Please ask for: Ms Iqraa Malik
Email: iqraa.malik@terraquest.co.uk
Telephone: 01212341390
Our Ref: EP/149/20/HH
Your Ref:
Date: 25th November 2020

Application for Planning Permission for Works or Extension to a Dwelling

Development: Erection of a single storey rear extension and second storey enlargement of side dormer and conversion of garage to study including demolition of existing conservatory. Addition of first floor window to southern elevation, to be opaqued, top hung opener with restrictor fitted. Resubmission following approved applications EP/166/18/HH and EP/165/19/NMA.

Location: 100 Sea Road East Preston BN16 1NP

Proposed Block Plan
1:500

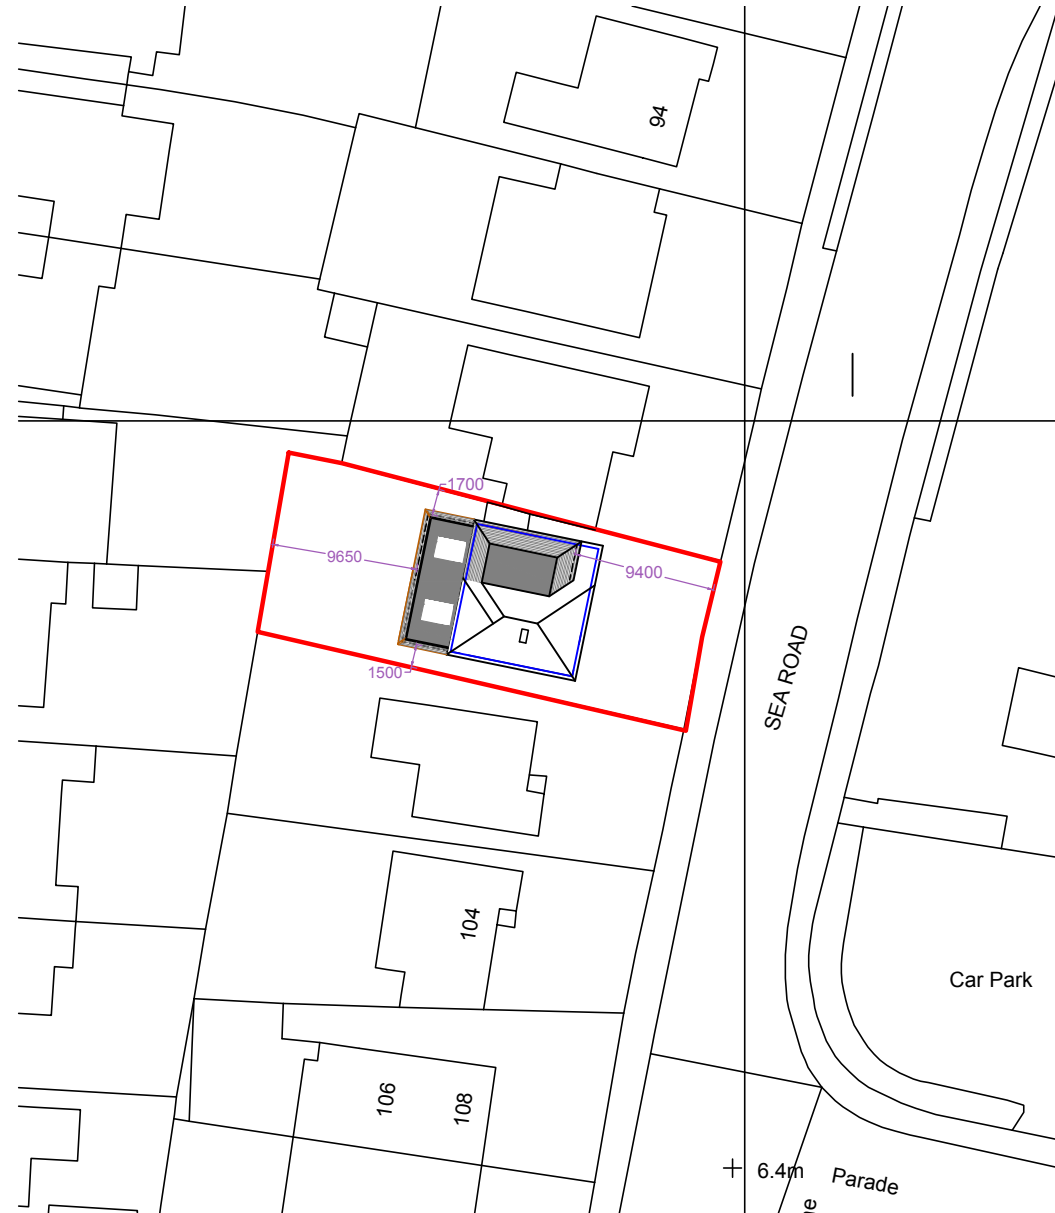
Block Plan

You are required to have dimensions from the proposed extension(s) to all site boundaries. Please amend.
